# OXFORDSHIRE COUNTY COUNCIL'S RESPONSE TO CONSULTATION ON THE FOLLOWING DEVELOPMENT PROPOSAL

**Application no:** 24/00245/OUT

**Proposal:** Outline application for demolition of existing structures and erection of up to 99 dwellings, access, open space and associated works with all matters reserved except for access

**Location:** South Lodge, Fringford Road, Caversfield, Bicester, OX27 8TH

Not to Scale
 Caversfield
Figure 3.1 – Local Facilities

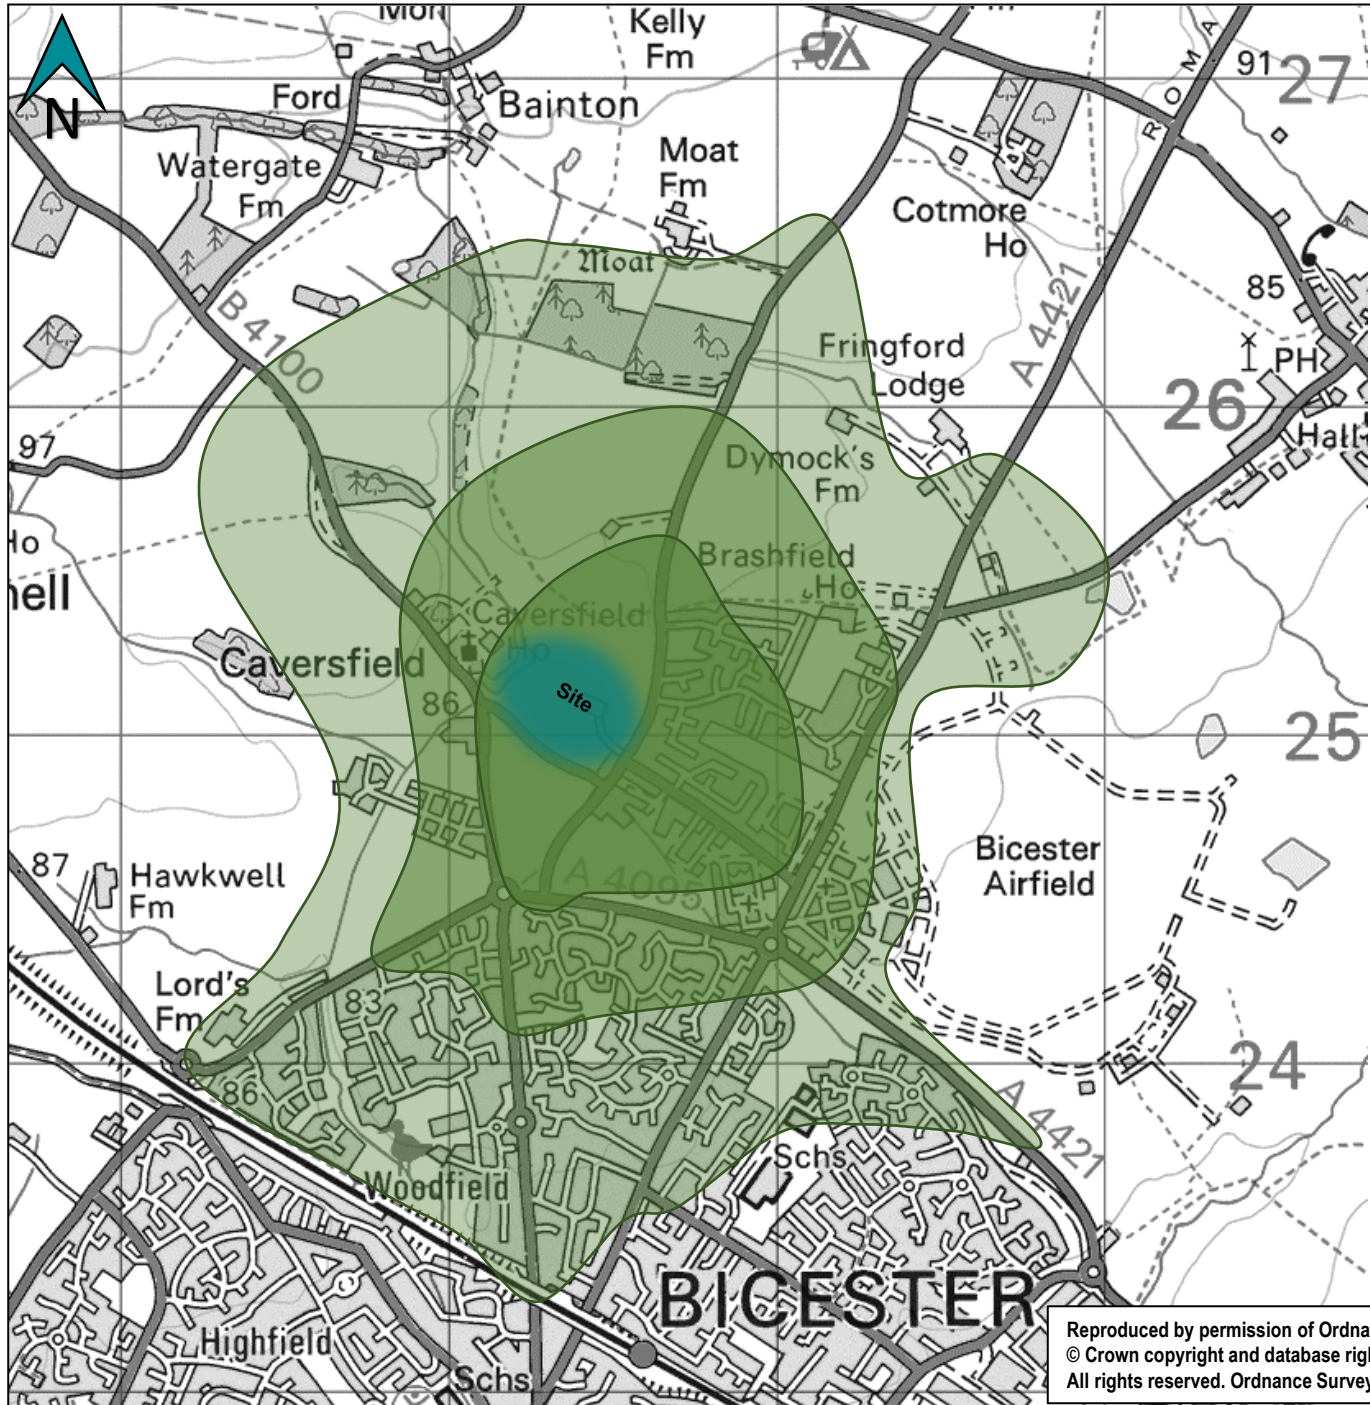
Table 3 shows the distances from the site to local facilities that are expected to be commonly used by residents of the proposed site. The TA does not disclose the exact point the distances have been measured from and therefore it cannot be accurately determined whether these amenities are conveniently accessible by residents on foot. The centre of development is considered an acceptable measurement point in this case. It can be determined however that from the measured location, no food shopping facilities are within the preferred maximum distance within the IHT guidelines.
